From: [Brenda Larsen](#)
To: [Jeff Watson](#)
Subject: Nowak SP-10-00009
Date: Friday, July 30, 2010 4:29:21 PM

After conducting a review of the above named project, I have the following comments:

*NOWAK*  
**ALEXANDER SHORT PLAT**  
WITHIN THE SW 1/4 SECTION 3 T18N R18EW  
KITITAS COUNTY WA.

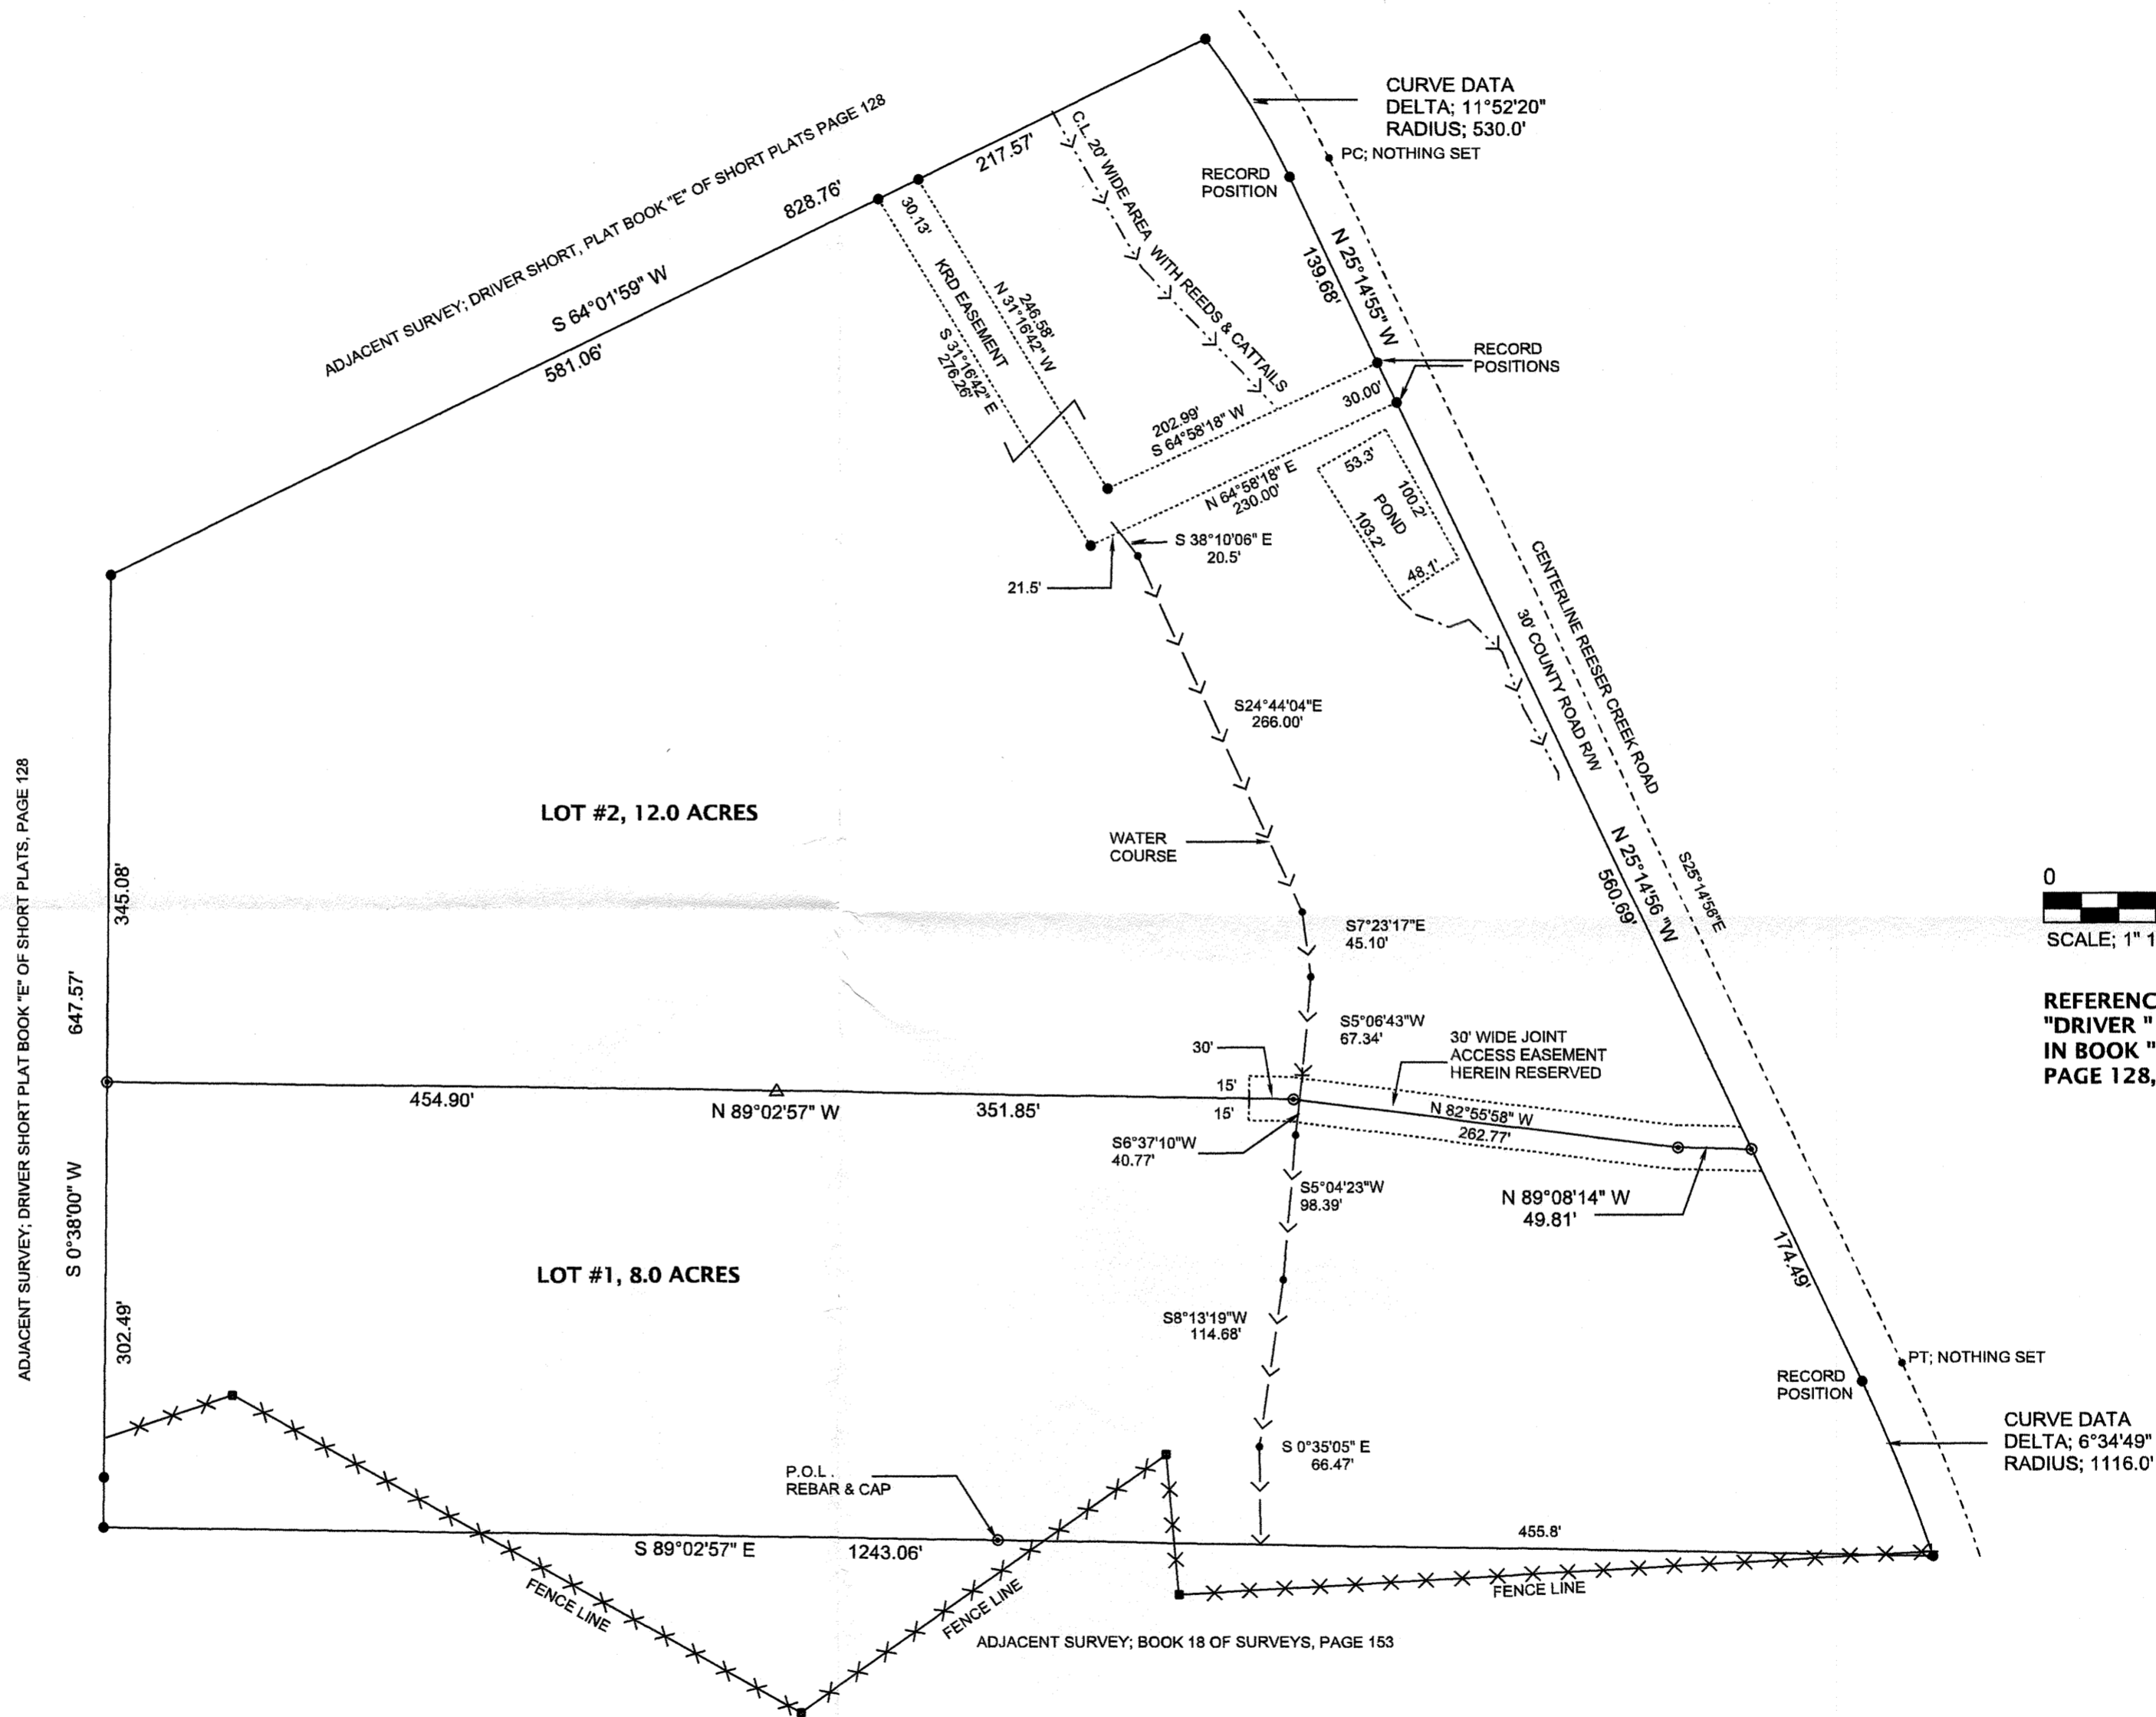
- A fire apparatus access road is required for access to these lots.
- All future development must comply with the International Fire Code.
